Application number: 2026/90452	
What is the application for?:	Erection of dwelling and associated works
Address of the site or building:	Land adj, Lower Common Lane, Scissett, Huddersfield, HD8 9HL
Postcode:

Type of comment: An objection	
Do you wish your comments to be published on the website anonymously?	No

Proposed Front Elevation (North west) 1:100

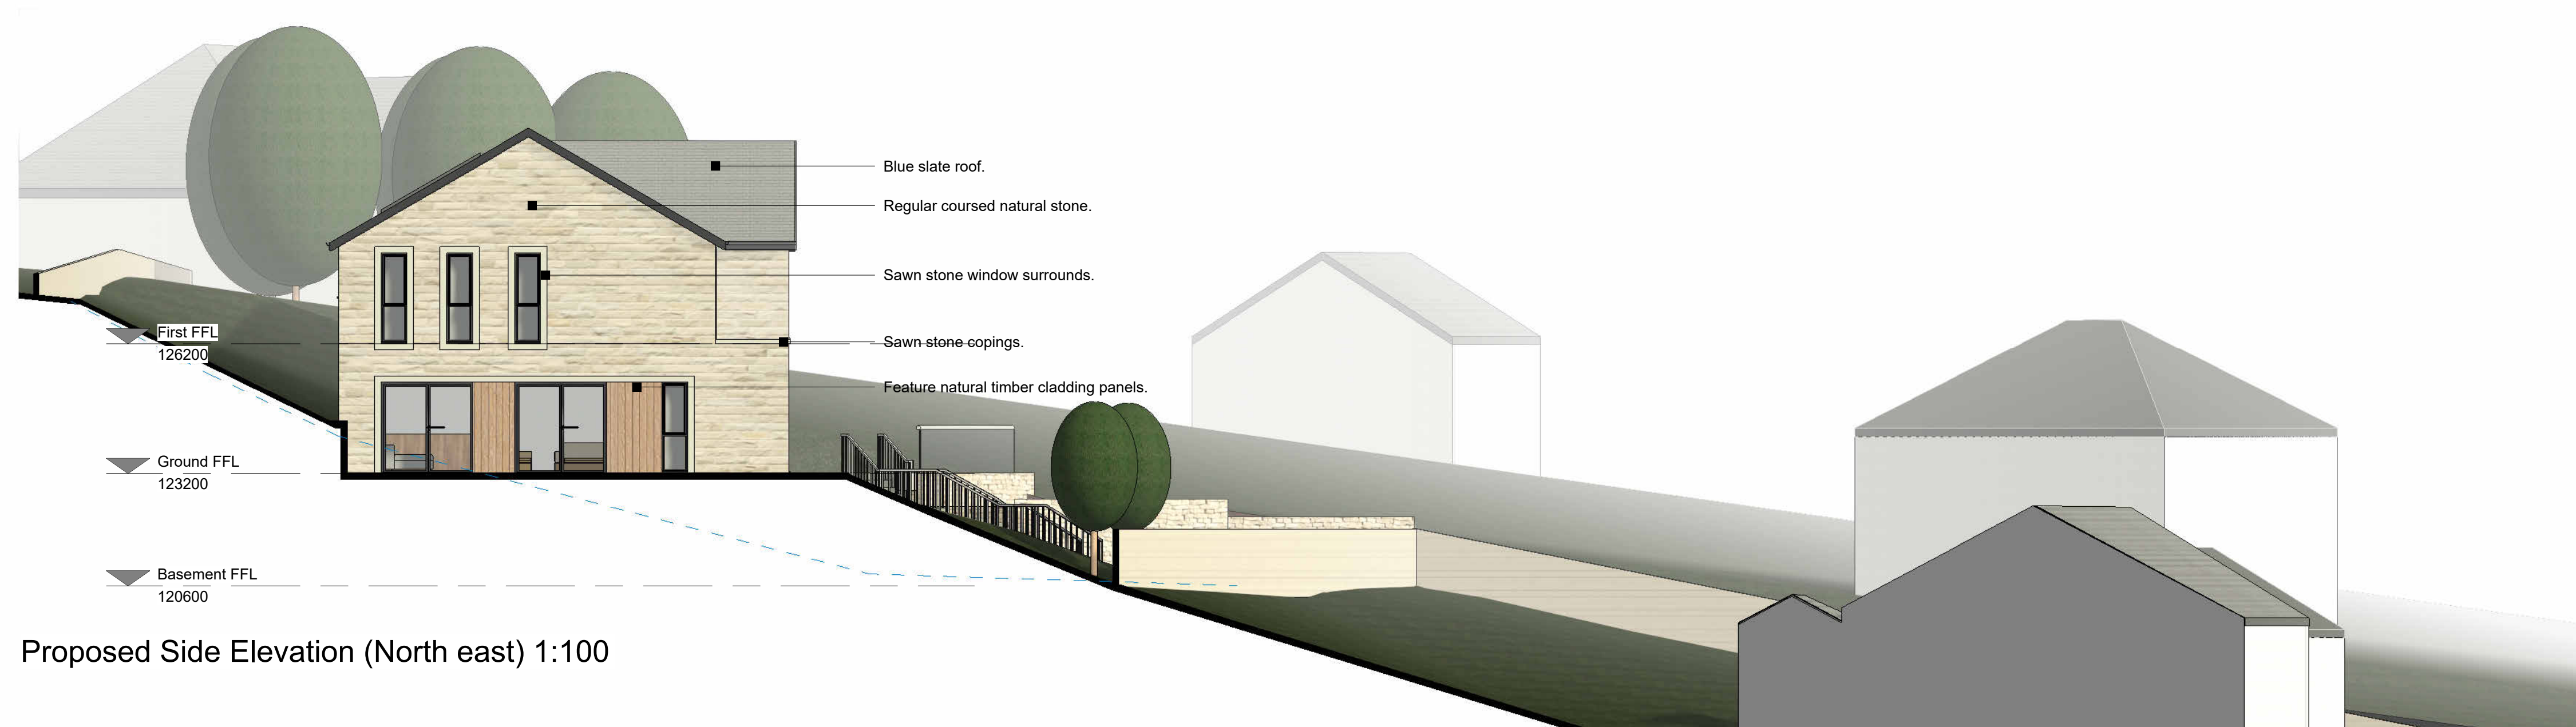
The proposed building design deviates considerably from the architectural character of surrounding properties, potentially leading to marked changes in the area's appearance and landscape. With a height exceeding three storeys, the structure could be perceived as imposing and incongruent with the established environment.

Proposed Site Plan 1:200

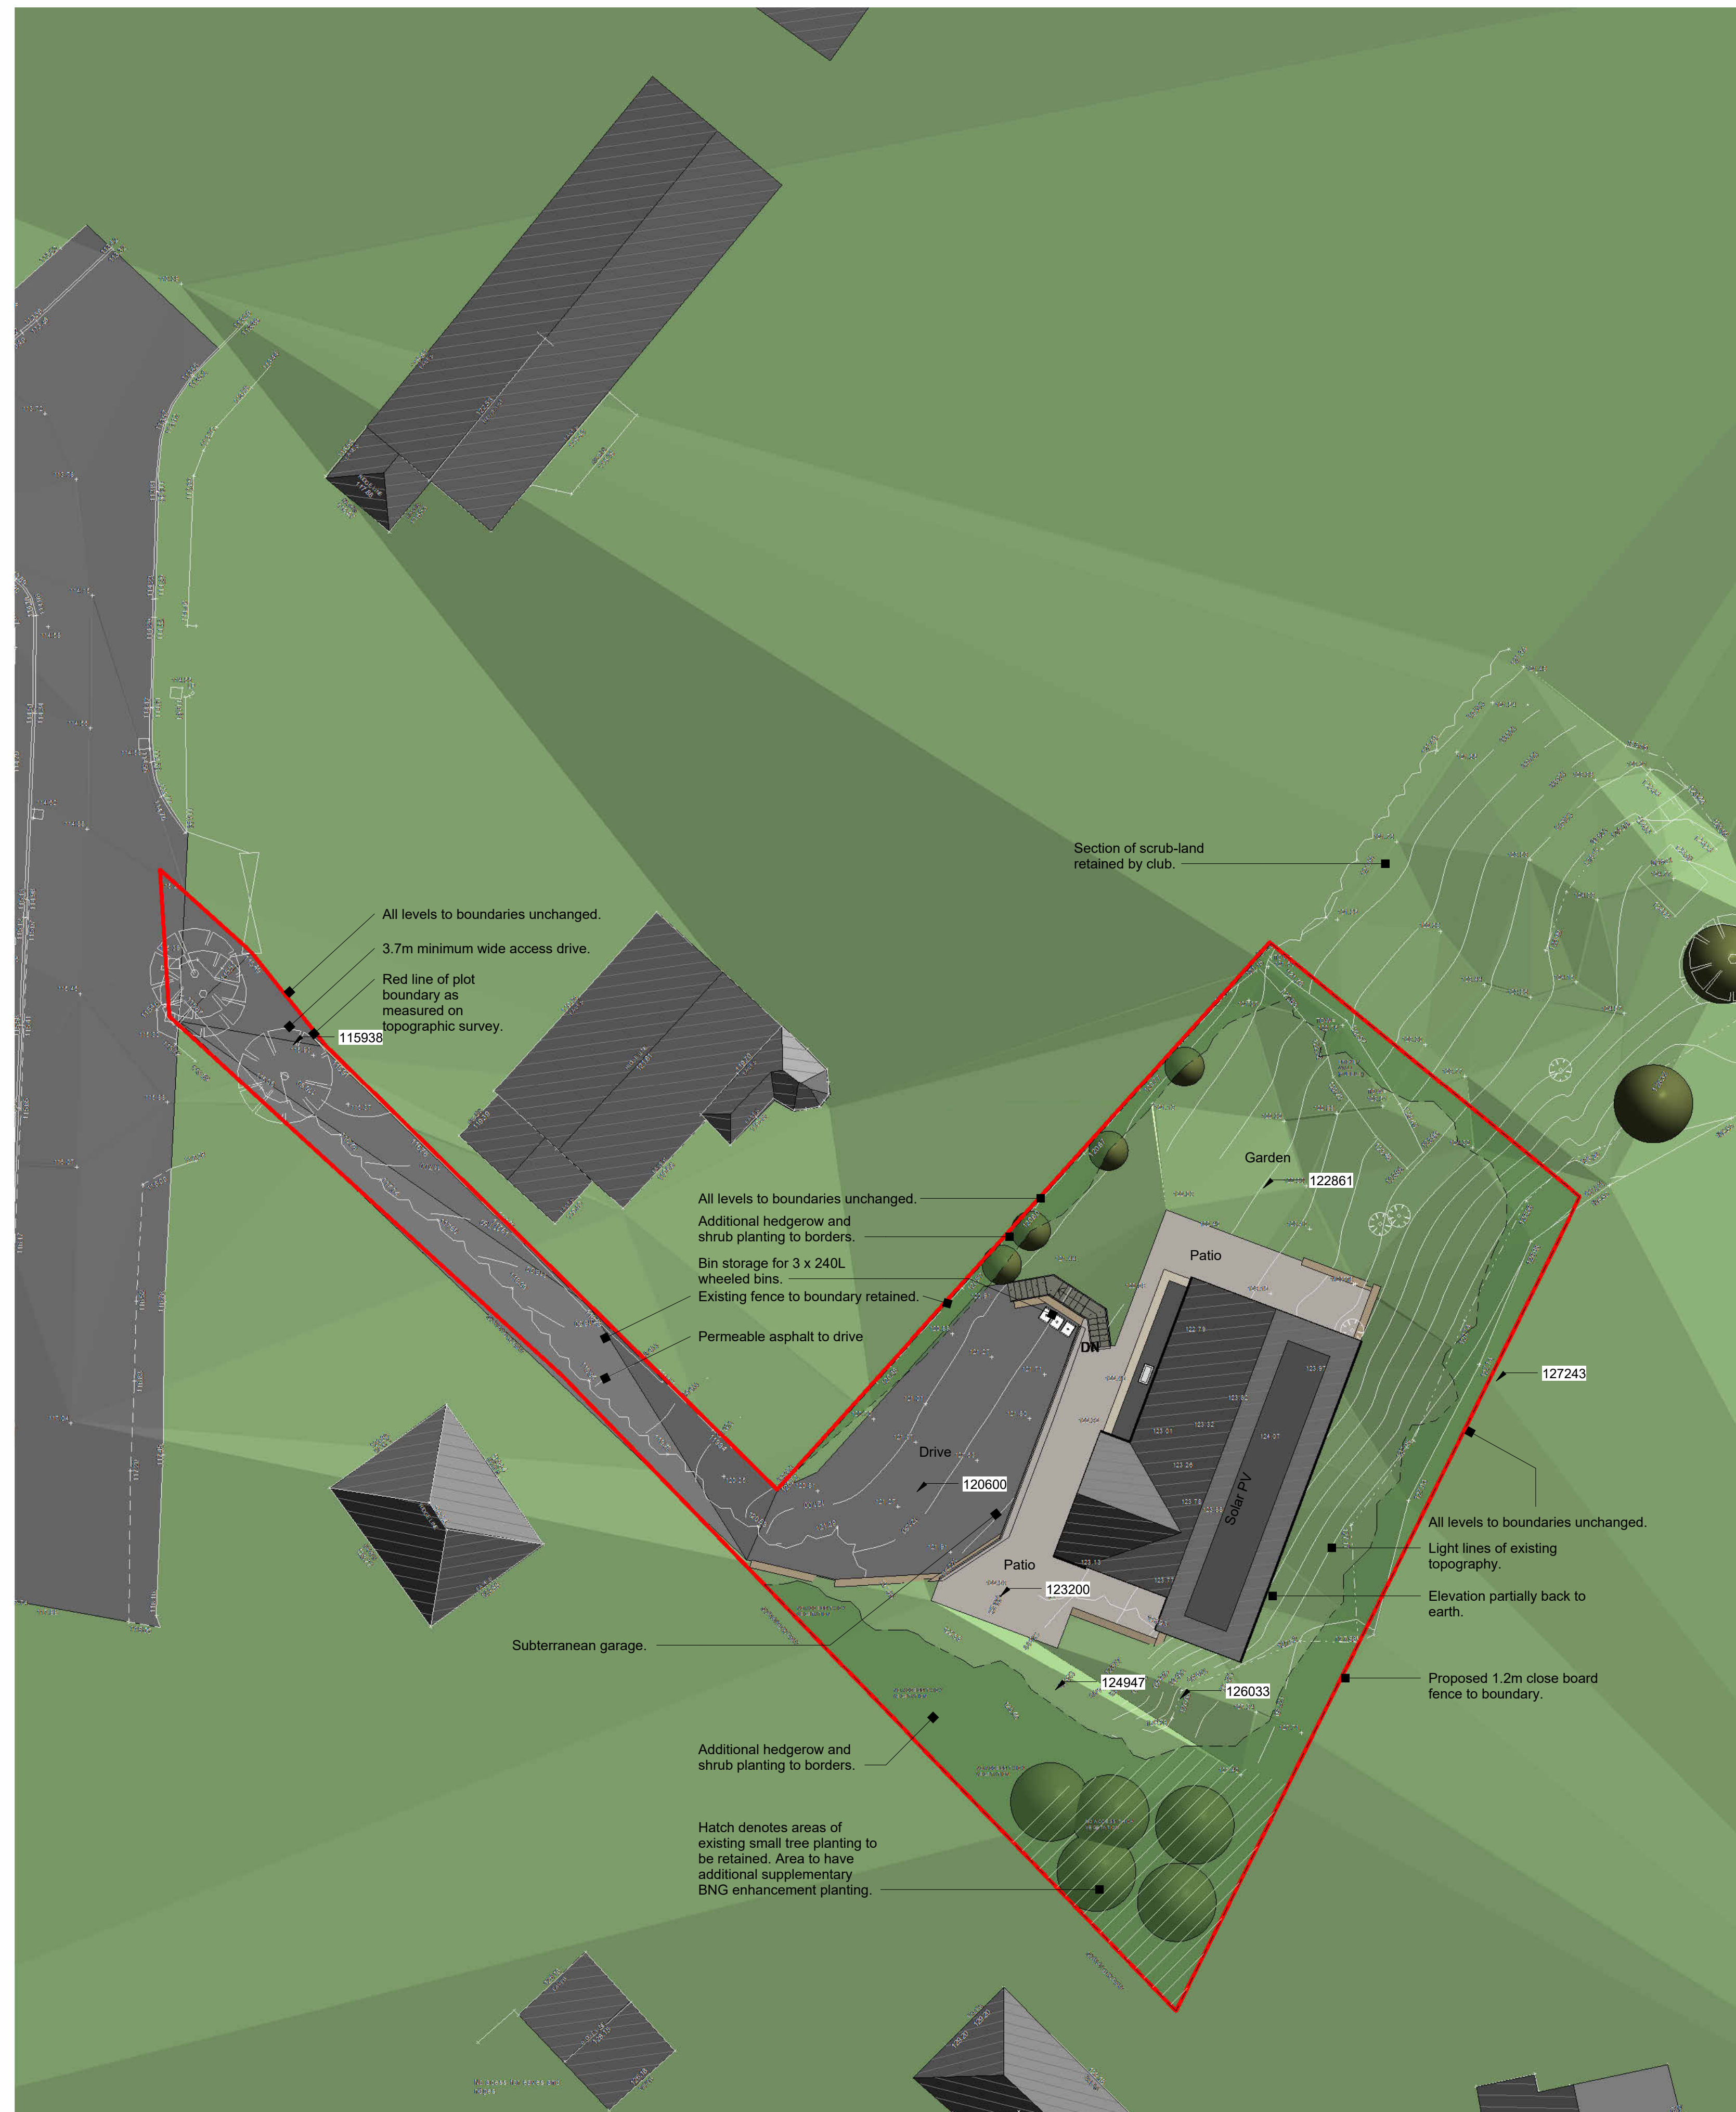
I wish to raise concerns regarding the proposed dwelling, specifically pertaining to accessibility and entrance to the subject land. Access is currently provided via a pedestrian pathway, which constitutes a private right of way. The entrance to this site is notably narrow and bordered by neighbouring property boundaries.

It appears impractical to turn into this entrance without encroaching upon adjacent properties or moving onto the opposite side of the road, potentially impeding oncoming traffic and access to the Nursery situated opposite. The proposal and associated plans do not seem to address these spatial constraints, nor do they indicate any safety measures that would facilitate convenient and secure entry for future residents while upholding the privacy and safety of current occupants.

Should access be modified to accommodate four vehicles, there will likely be implications for both the safety and function of the existing private right of way. Such alterations could introduce additional safety risks for road users and pedestrians on Lower Common Lane.

Significant disruption during excavation and construction phases is anticipated, given the limited access to the site, with potential adverse effects on nearby properties and businesses. It appears unlikely that heavy vehicles could access the land without infringing on neighbouring parcels. Increased traffic associated with the development may also pose risks for the Nursery opposite, especially concerning pedestrian and child safety.

This junction serves multiple users, including access to homes on Barnsley Road, a Nursery car park, and two private properties, all within a compact area. Introducing another property entrance could exacerbate existing congestion, affecting traffic flow, parking, and pick-up/drop-off activities at local schools and the nursery.
